STATUTORY PLANNING CONSULTATION RESPONSE

Application Number:	3/2026/0400
Proposal:	Approval of details reserved by conditions 15 (surface water operation and maintenance); 16 (surface water verification report); and 17 (new build units verification) on planning permission 3/2022/0966.
Location:	Crow Trees Farm Crow Trees Brow Chatburn BB7 4AA

Client: Pringle Homes
Project: Crow Trees Farm, Chatburn
Drawing Title: Foul and Surface Water Drainage Plan

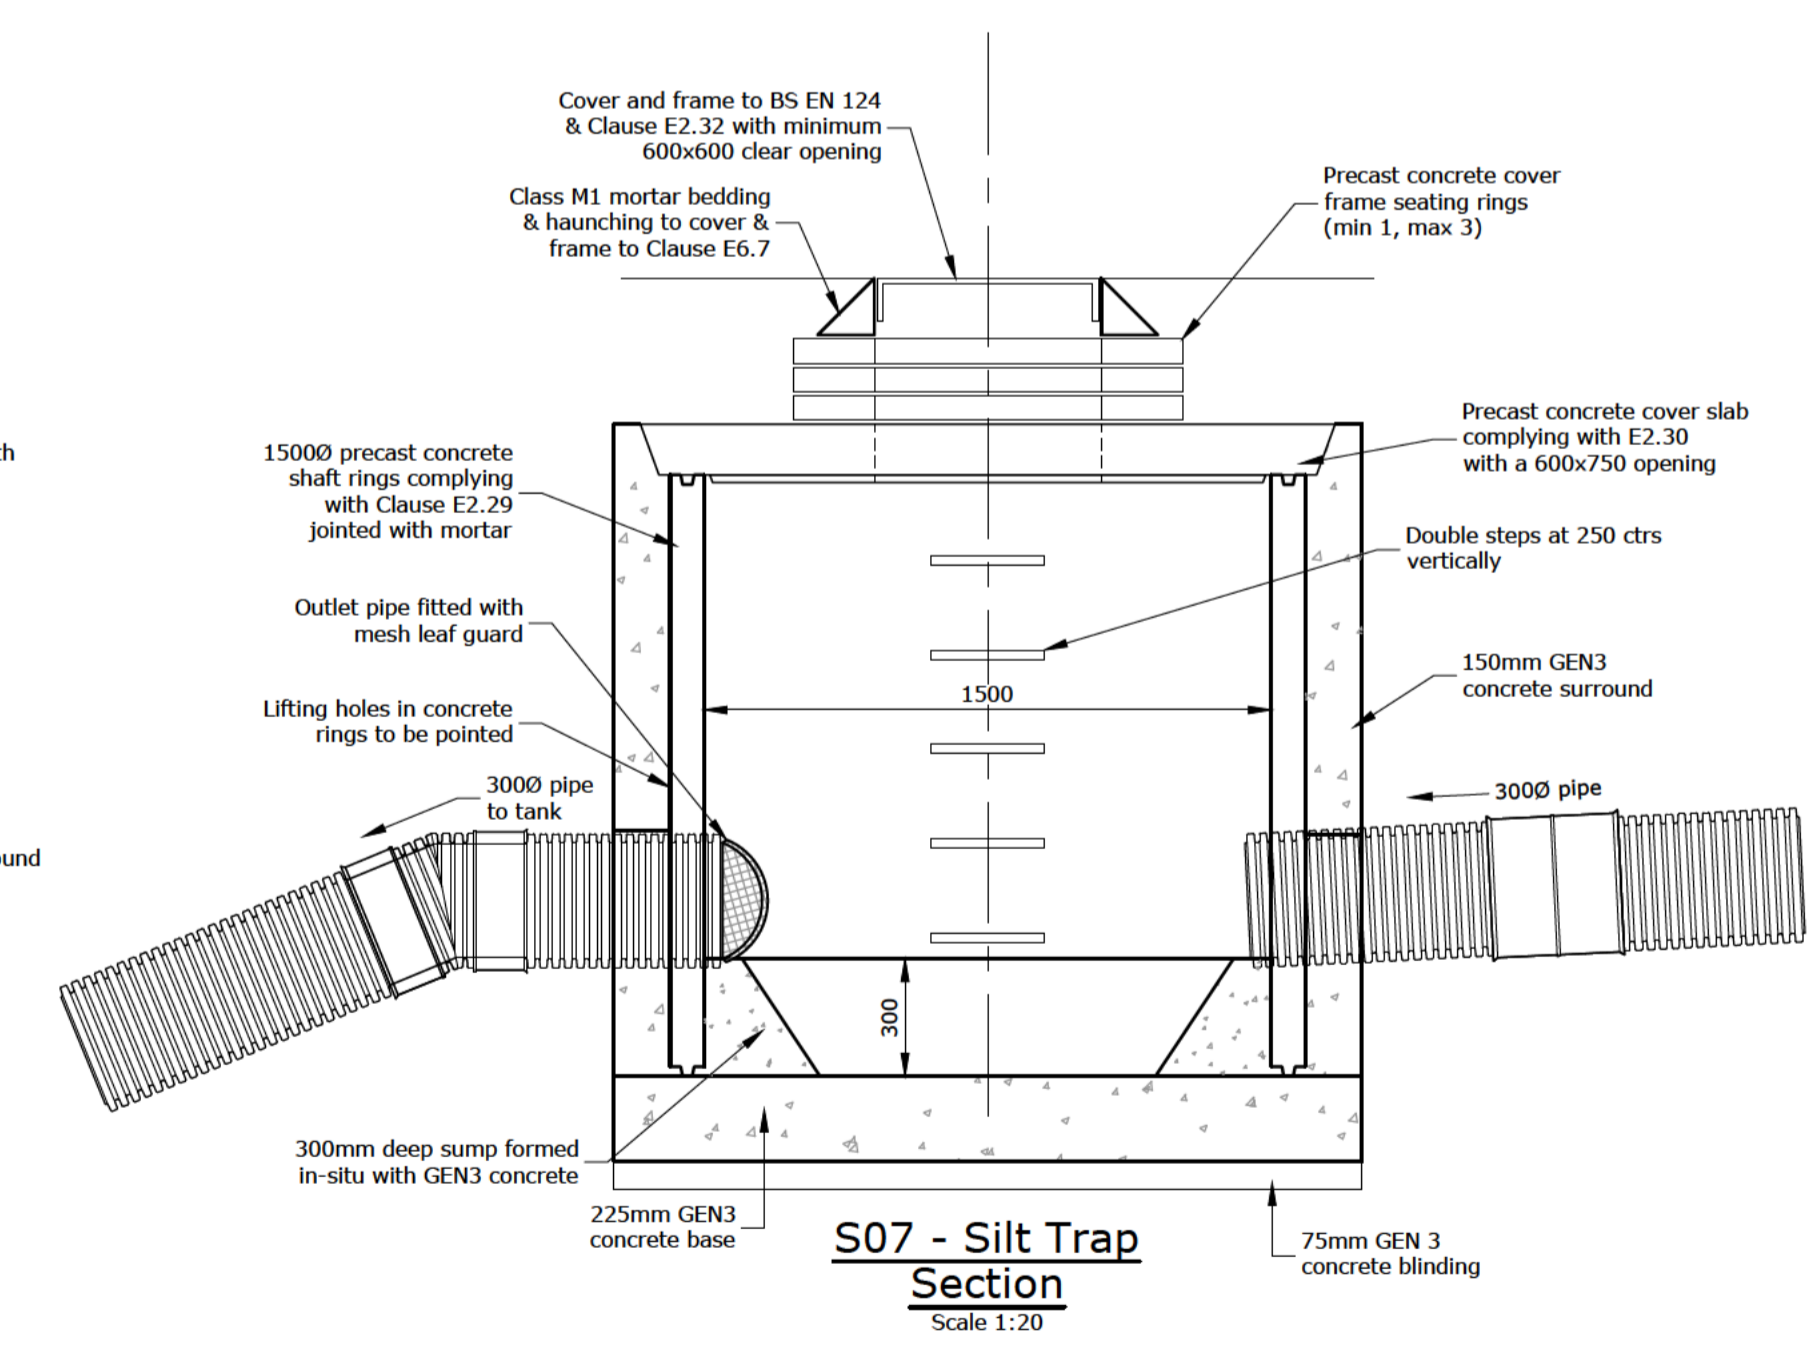
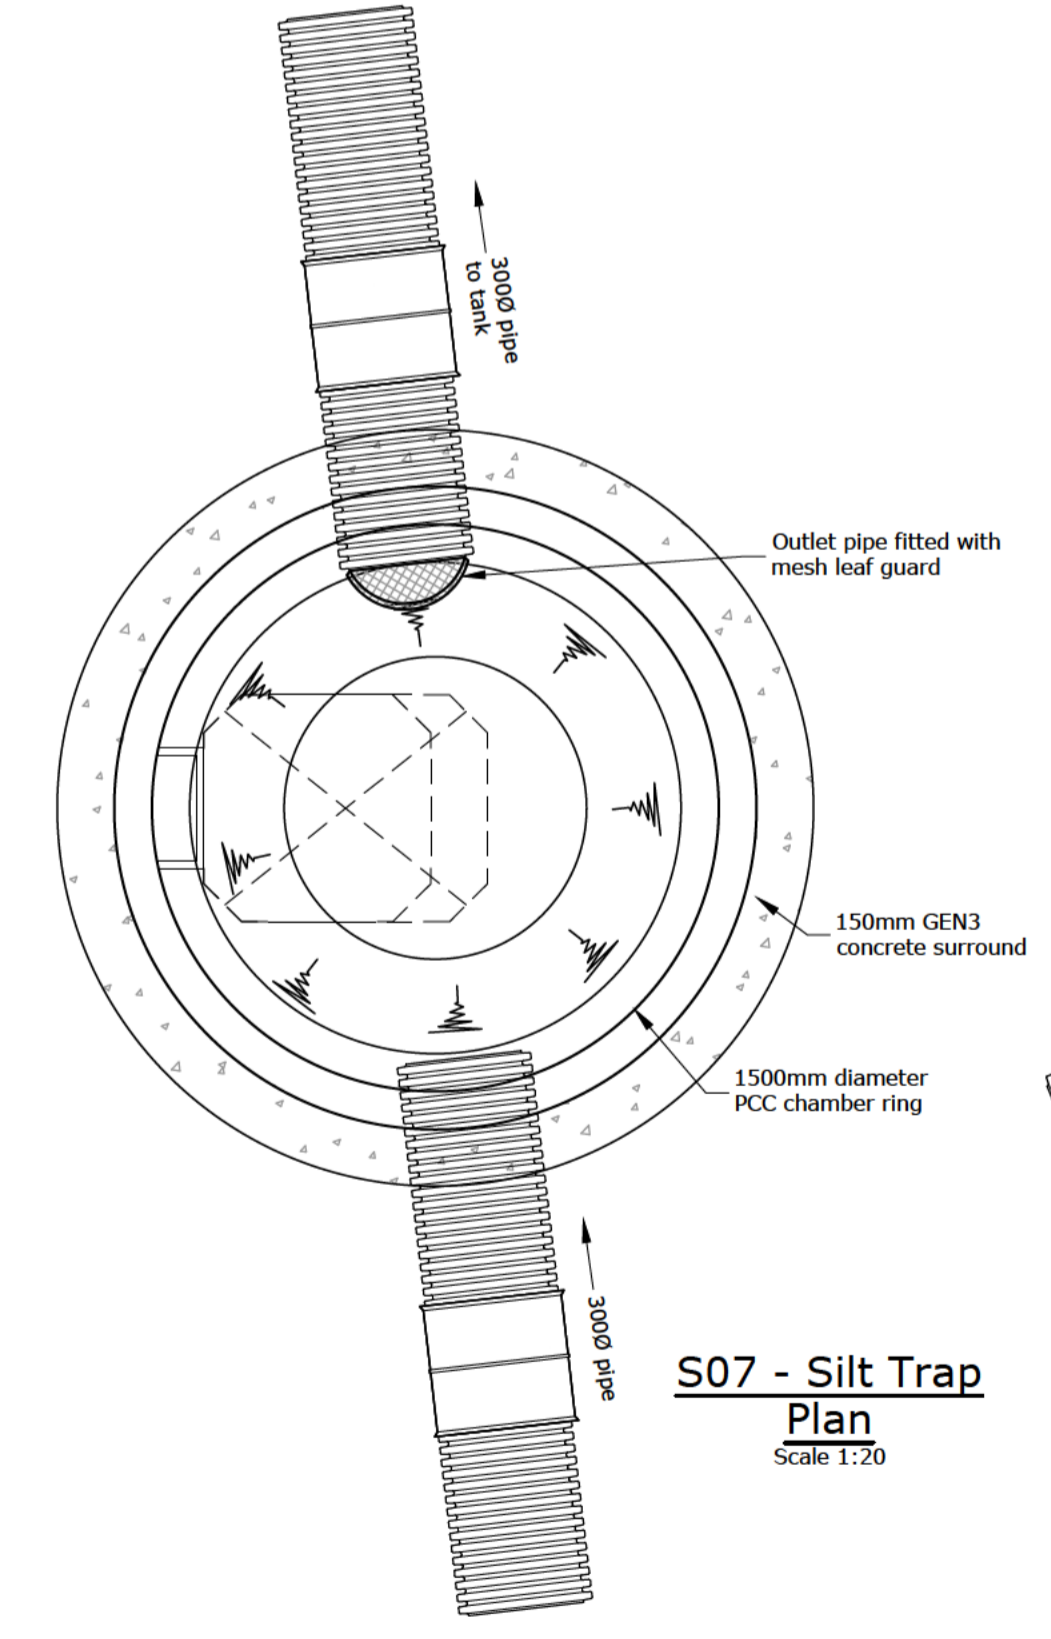
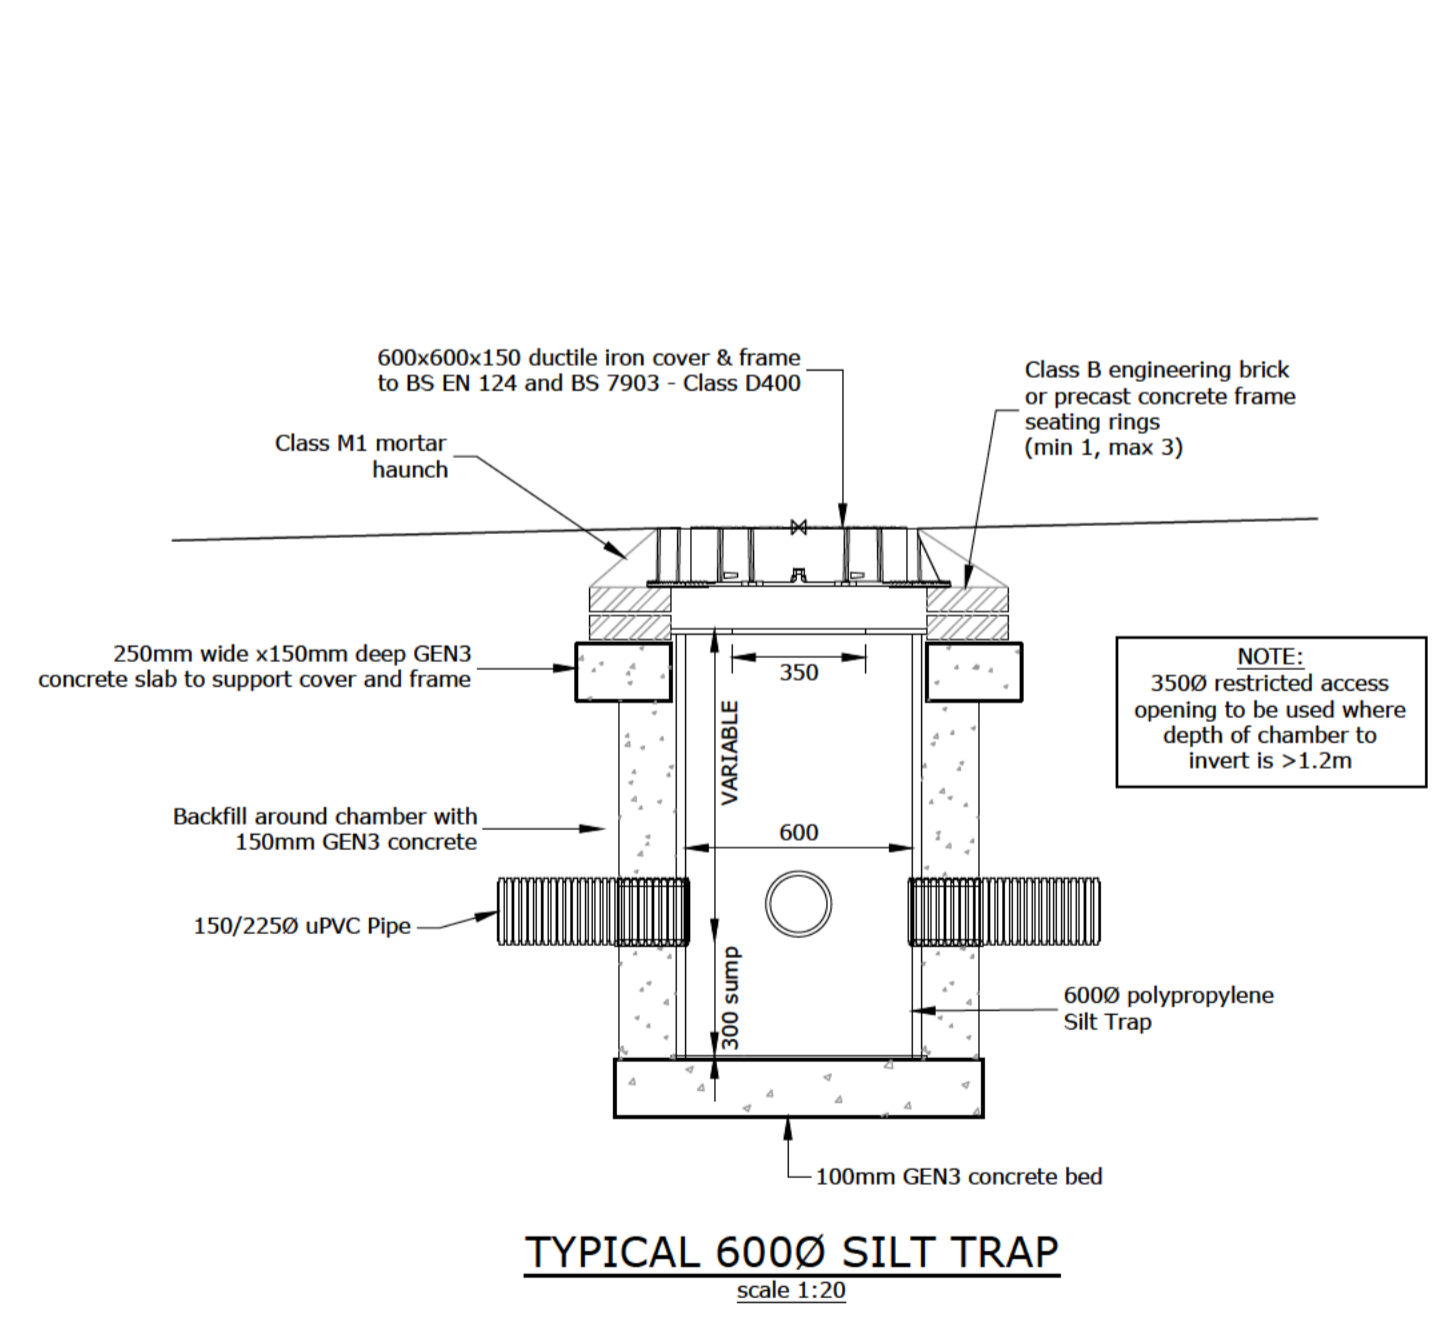
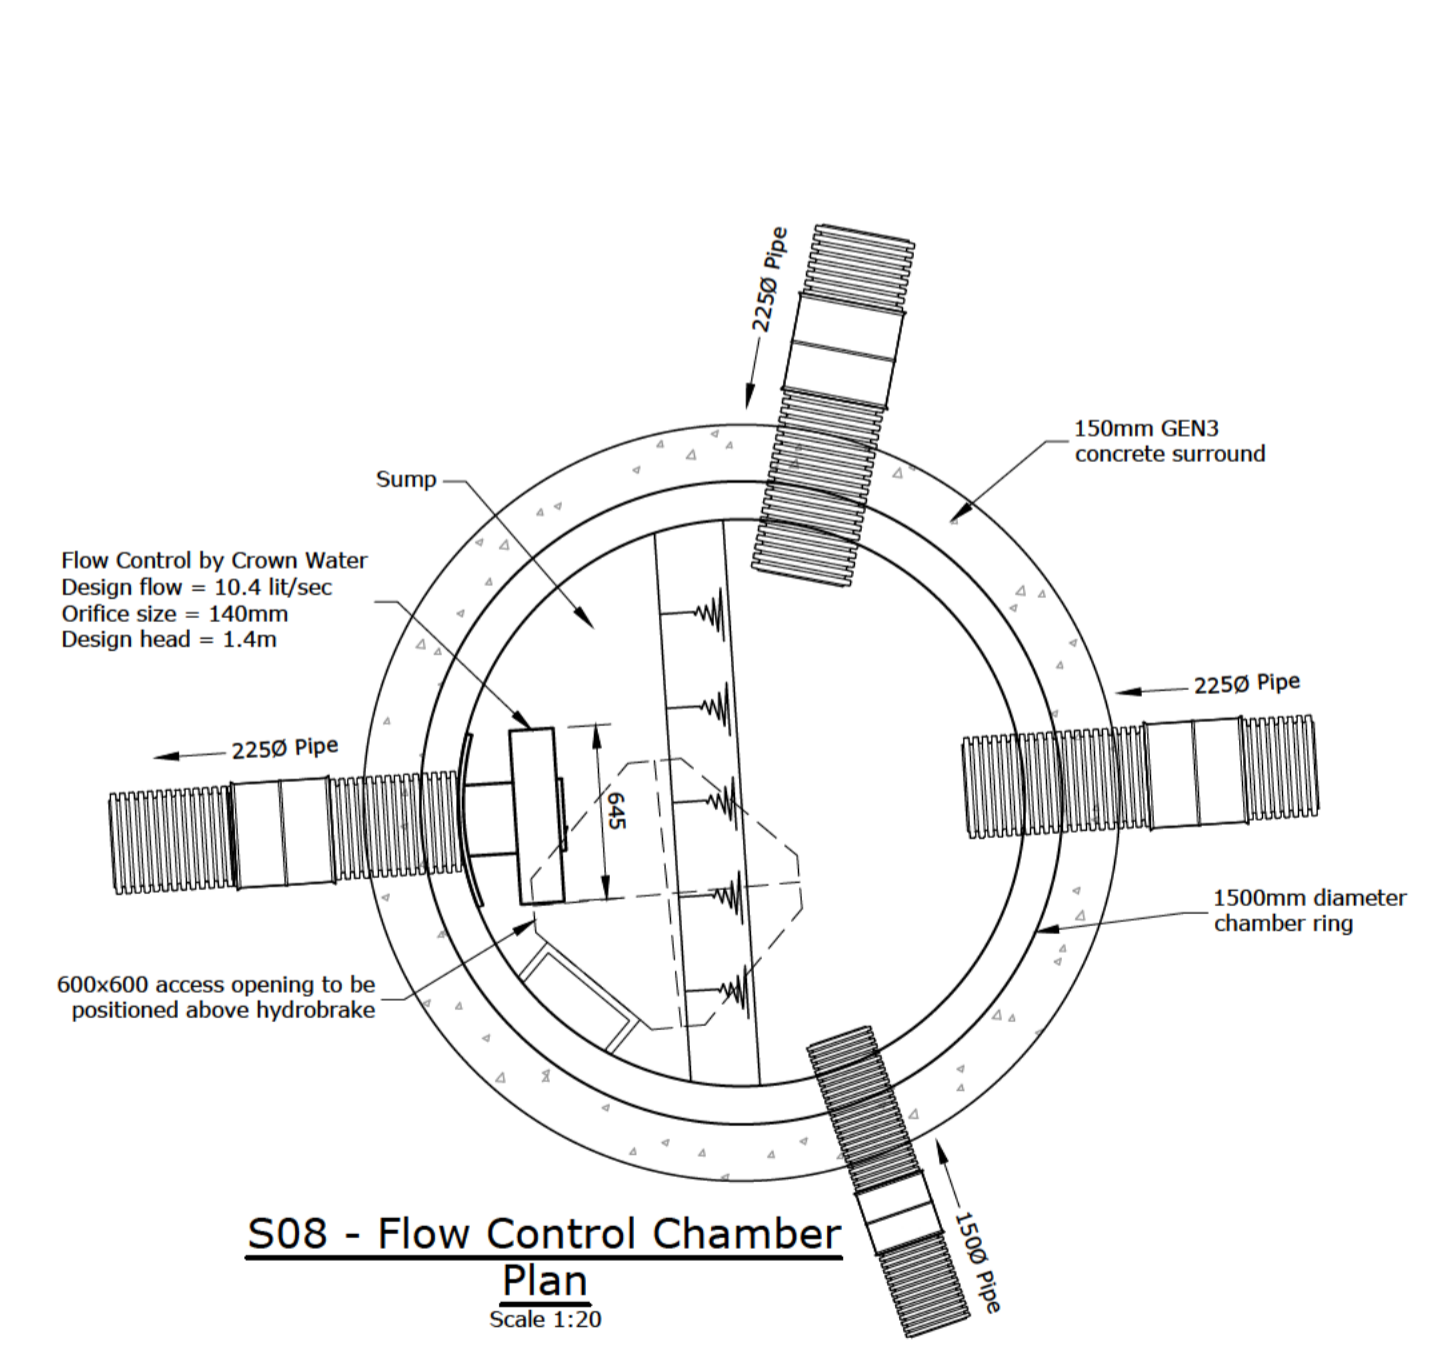
- The Local Planning Authority should satisfy itself that the applicant has put the appropriate measures in place and mitigate against residual risk given the applicants alterations, and having a combined surface water and foul drainage connection. The applicant has met the wording of the aforementioned conditions, however the applicant has proposed that a non-return valve is not required, despite the combined connection point (C03) showing that the foul water entering this chamber at a higher inlet level than that of the surface water, meaning that should a blockage or problem occur between C03 and C02, and the system were to start backing up, foul water has the potential to backup along the surface water drainage system, which has inherent risks.

For the avoidance of doubt, the applicant has not given evidence of a simulation model of the two systems combined up to the final outfall, given that these systems now have the potential to interact and affect each other.

It is widely acknowledged as the industry standard as to drain foul and surface water on separate systems, this deviation, should have been highlighted at a much earlier stage and assessed or re-assessed through the final detailed surface water sustainable drainage design and/or condition, as this change has the potential to affect the drainage of the development and its associated flood risk if not managed appropriately.
